**PLAN REVIEW SHEET**

**Petition #: RZP 2022-052**

**Address: 6112 Tuckaseegee Road**

**Request: R-17MF (CD)**

SHEET NO.
RZ-1

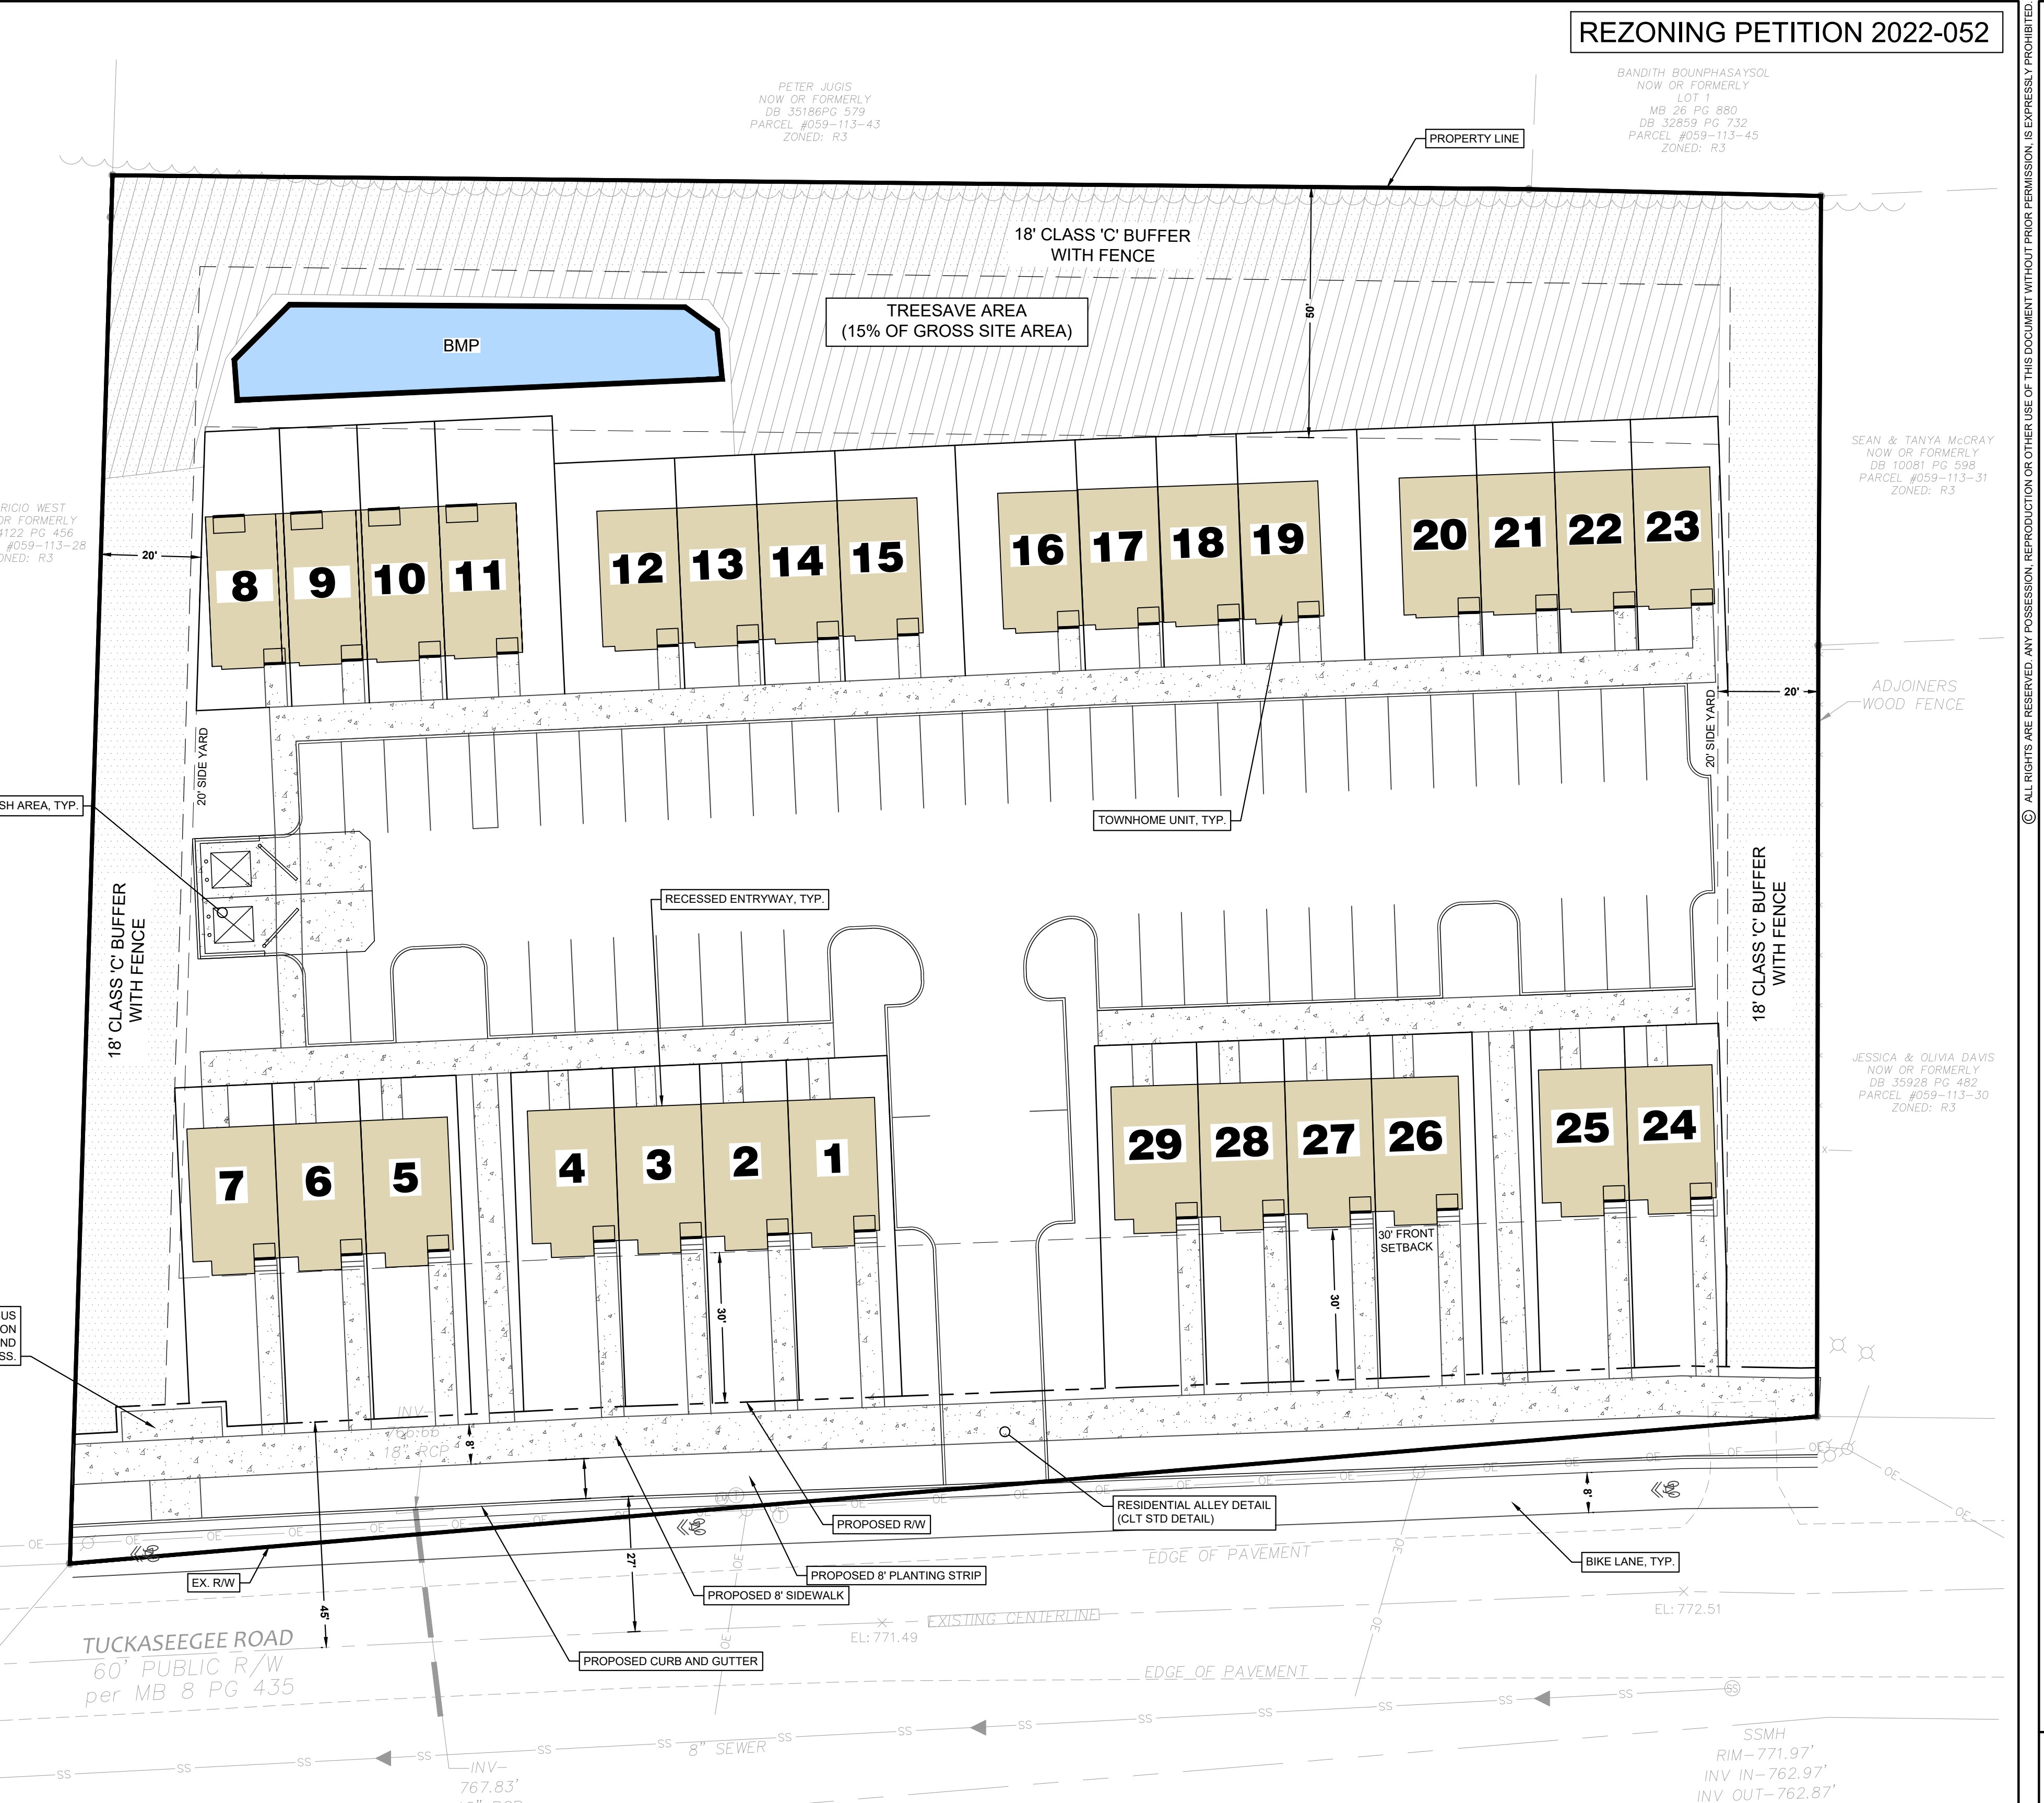
The site is located along CATS local bus route #8 on Tuckaseegee Rd. CATS requests the construction of a new ADA compliant waiting pad per Land Development Standard 60.03A. The final location will be determined during the Land Development plan review process.
